## 88 Preble- zoning issues re Alder St frontage

Jean Fraser <jf@portlandmaine.gov>

I have discussed your latest (3.15.16) plans with Ann Machado and am writing with comments as they do not meet zoning as shown.

**FLOOR PLAN**  
 SCALE: 3/16" = 1'-0"

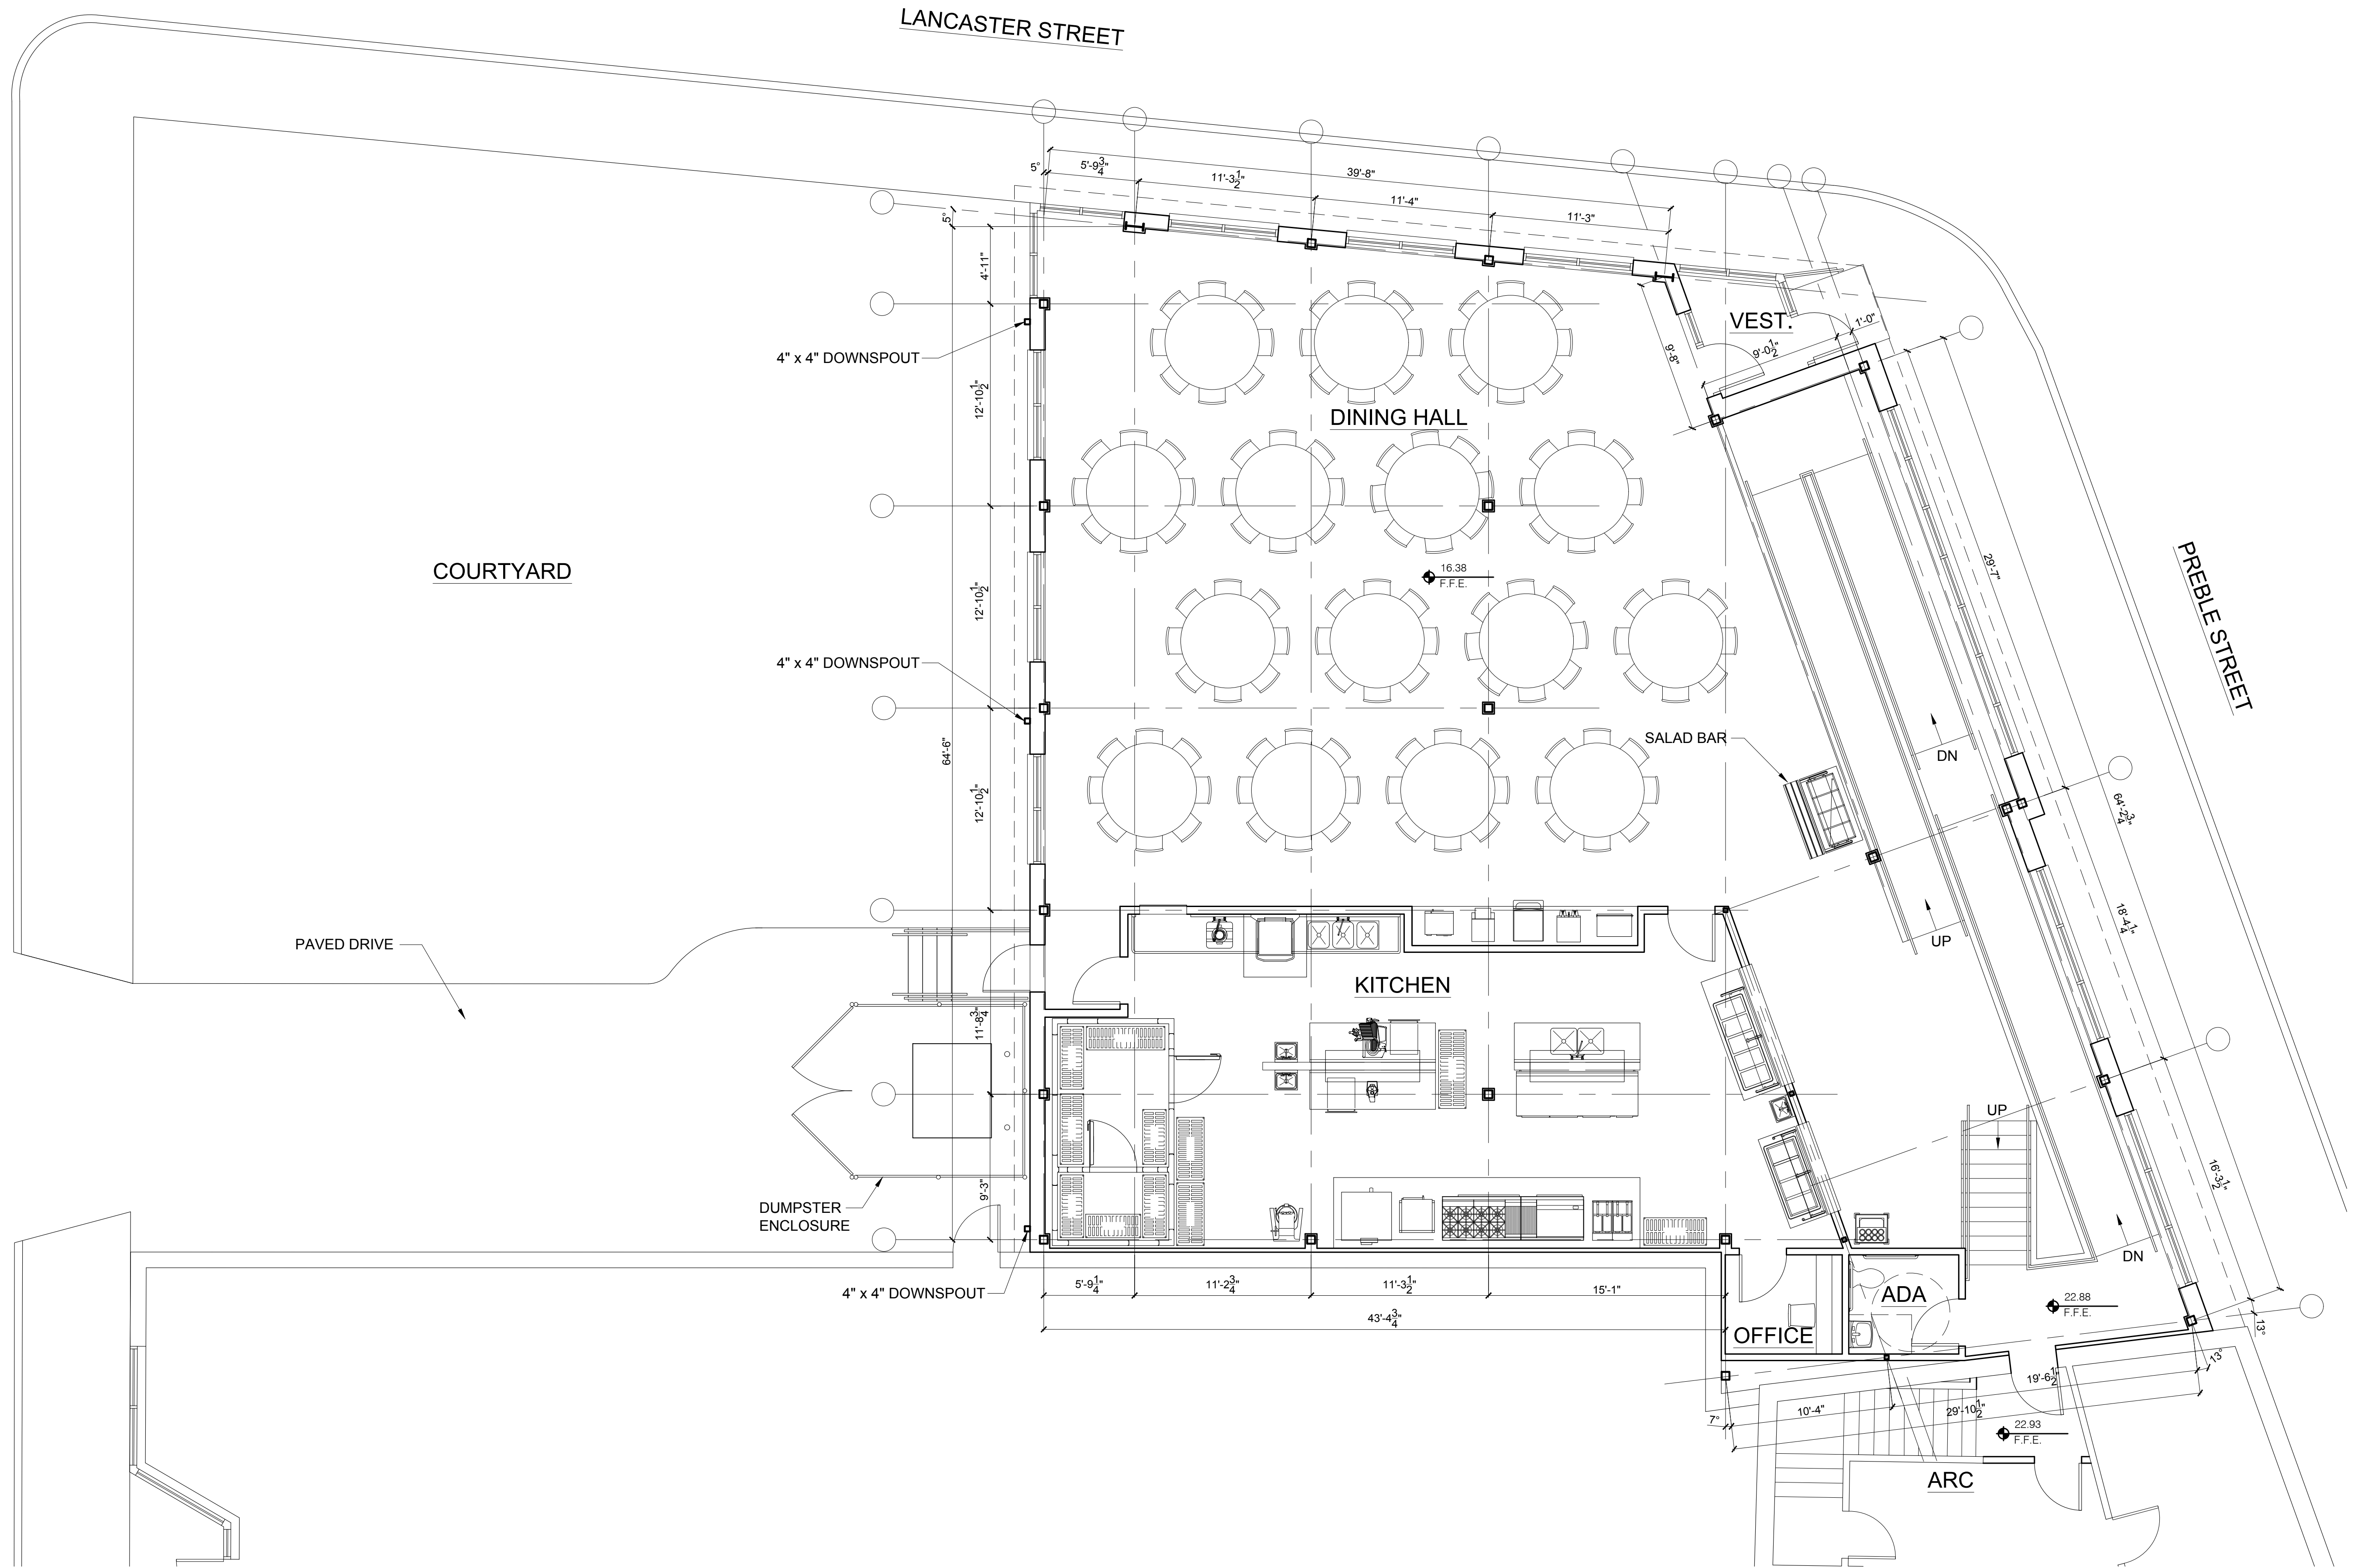
- The basic principle is that whatever is in the setback in terms of structures should be the minimum necessary to meet ADA code or fire egress requirements;

- The previous plan (discussed 2.11.16) just showed a ramp "hugging" the building, and that was the basis of the previous comments which related to placement of a ramp in the setback;

- Adding landscape by the sidewalk (in the latest plan) helps make the ramp-only piece more compliant re the 10 foot setbacks;
- Adding the large stairs and second landing (as in the latest plan) makes the proposals less compliant. The stairs appear to be un-necessary as this door is for egress only. This is the main reason these proposals are unacceptable re zoning/setback requirement;

- Regarding the building bump-out - your plans are not dimensioned but if the base of the building is 10 feet from the property boundary and if the overhang is a maximum of 2 feet with no foundation, then that is OK;

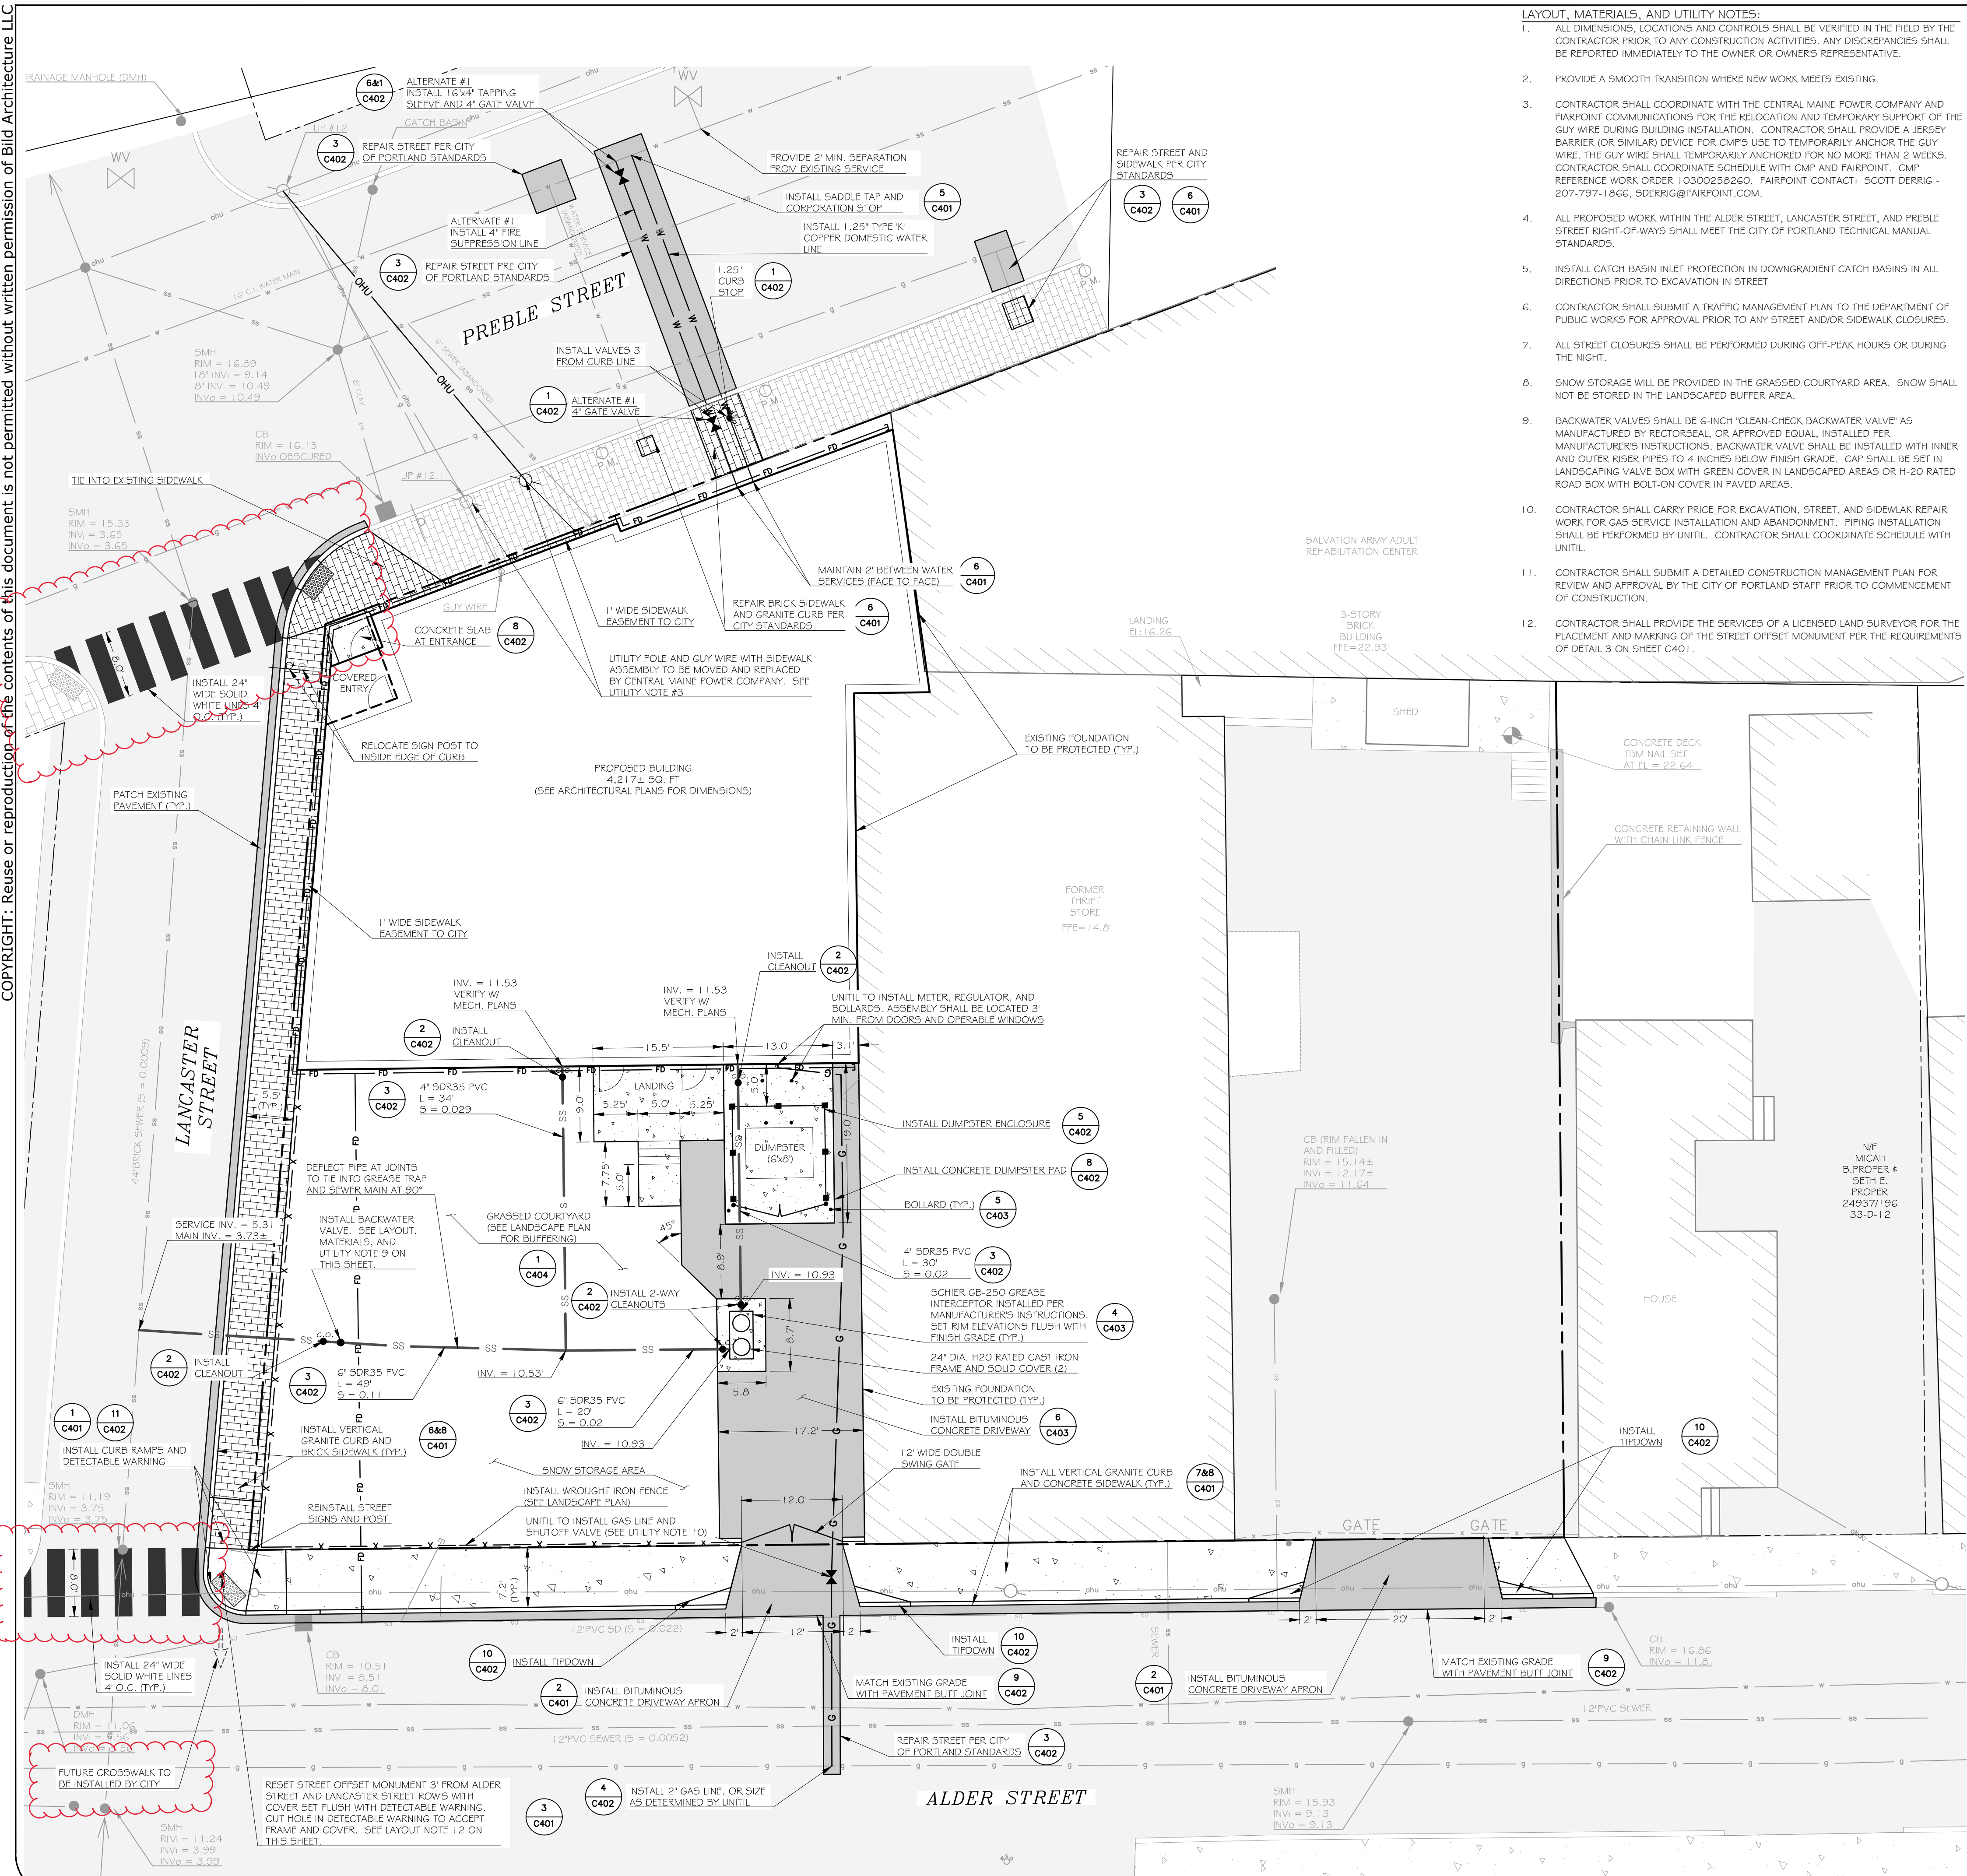
- When sending revisions for comments, please send the proposal on the site plan (that shows the property boundary) and please add key dimensions.
